Our Ref 22-2335
Your Ref 17/00857/RM

Detached dwelling at 128 Old Roman Bank, Terrington St Clement

Planning enforcement have now raised these issues and we have prepared plans for the dwelling as built, and wish to regularise these via a section 73 planning application to vary the plans referred to on the original planning permission.

No	Date	Revision
Issue: For Planning Approval		
Site: 128 Old Roman Bank, Terrington St Clements, Norfolk, PE34 4JP		
Project: Residential Development		
Drawing Title: As Built Floor Plans		
Client: Mr and Mrs Chapman		
Date	February 2023	
Scale	1:50 at A1 or 1:100 at A3	
Drawing Number	P-22-2335-3

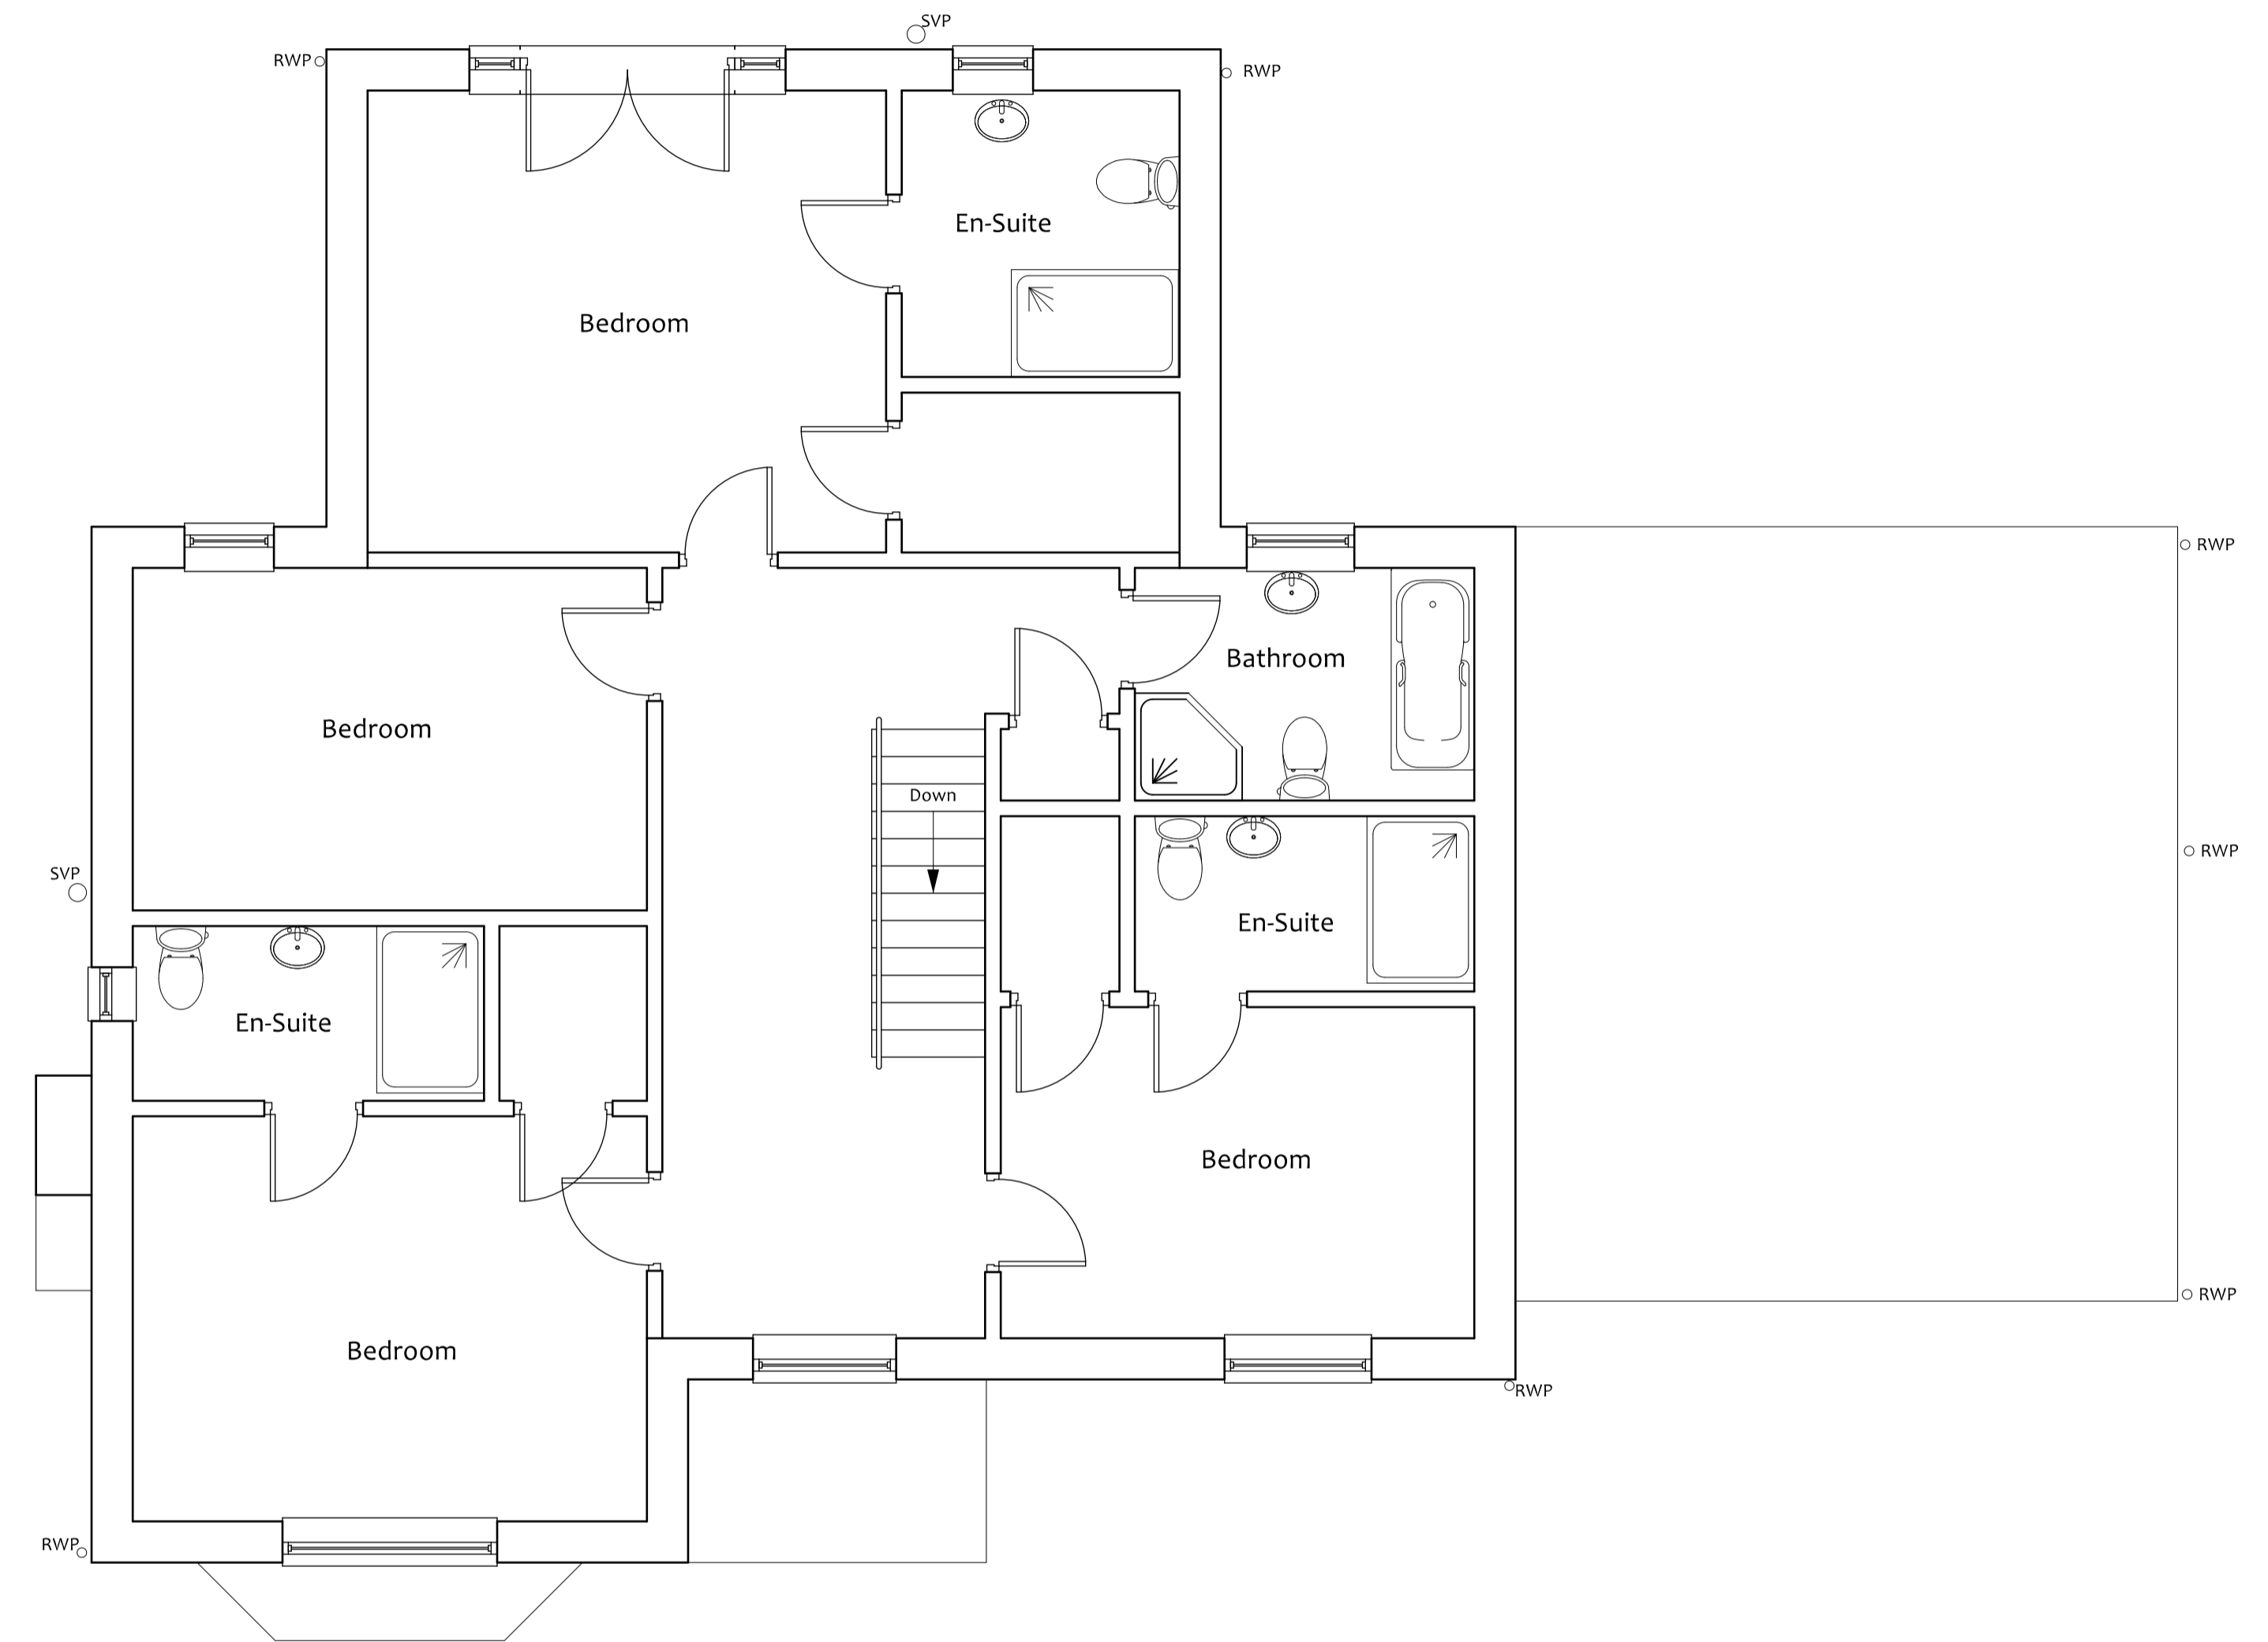
1. The provision of a smaller attached garage as opposed to the larger, detached double garage approved.
2. A single, sectional door to the garage.
3. An oak framed open porch, as opposed to the proposed brick-built porch.
4. The provision of solar photovoltaic (PV) panels installed on the south facing roof elevation.
5. Change of roof tiles to an Antique slate, clay tile chosen instead of IMERY'S Pan H2 Burnt Red concrete tile to minimise impact of PV panels.
6. Omission of obscured glazing to bathroom/en-suite windows.

7. Dining room window on ground floor altered to become a full length window.
8. Change of bricks used in external walls due to lack of availability.
9. Change of window and door colour.

No	Date	Revision
Issue: For Planning Approval		
Site: 128 Old Roman Bank, Terrington St Clements, Norfolk, PE34 4JP		
Project: Residential Development		
Drawing Title: As Built Site Plan		
Client: Mr and Mrs Chapman		
Date	February 2023	
Scale	1:500 at A3	
Drawing Number	P-22-2335-2

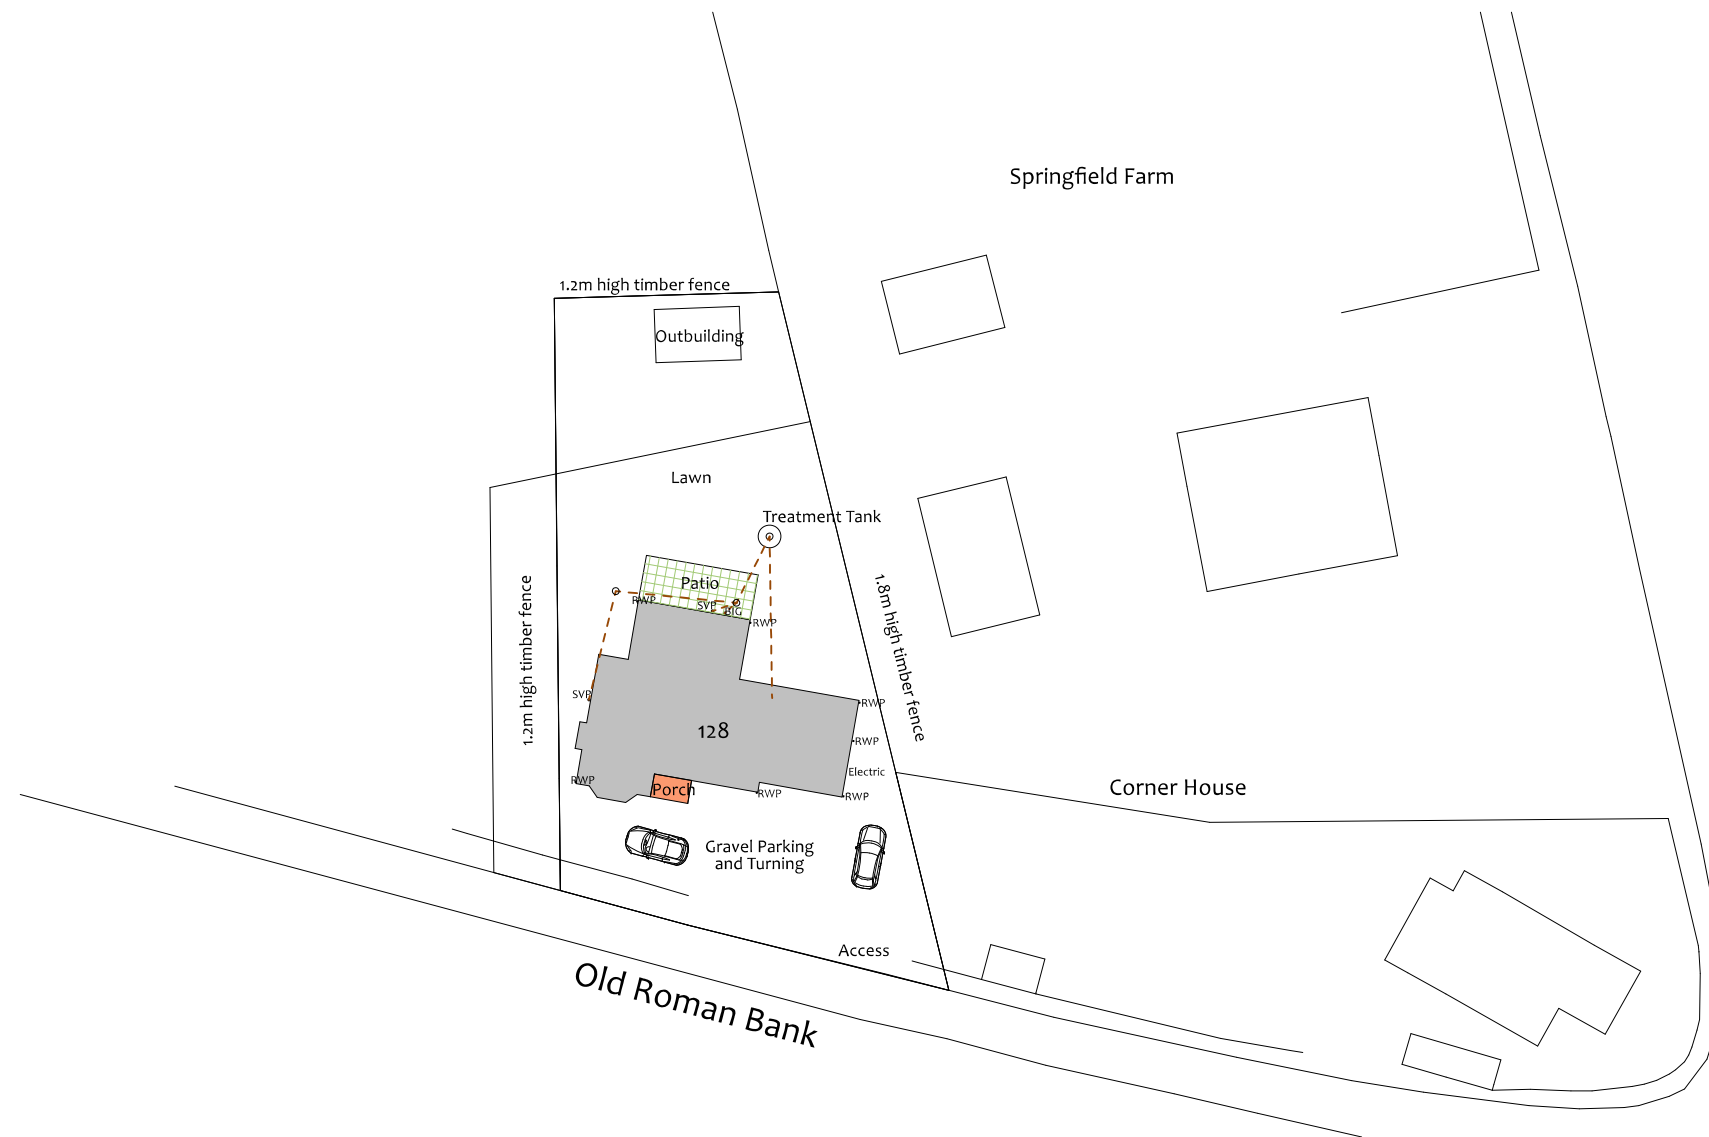
A separate application is also to be submitted to cover the extended curtilage and the erection of an outbuilding within this.
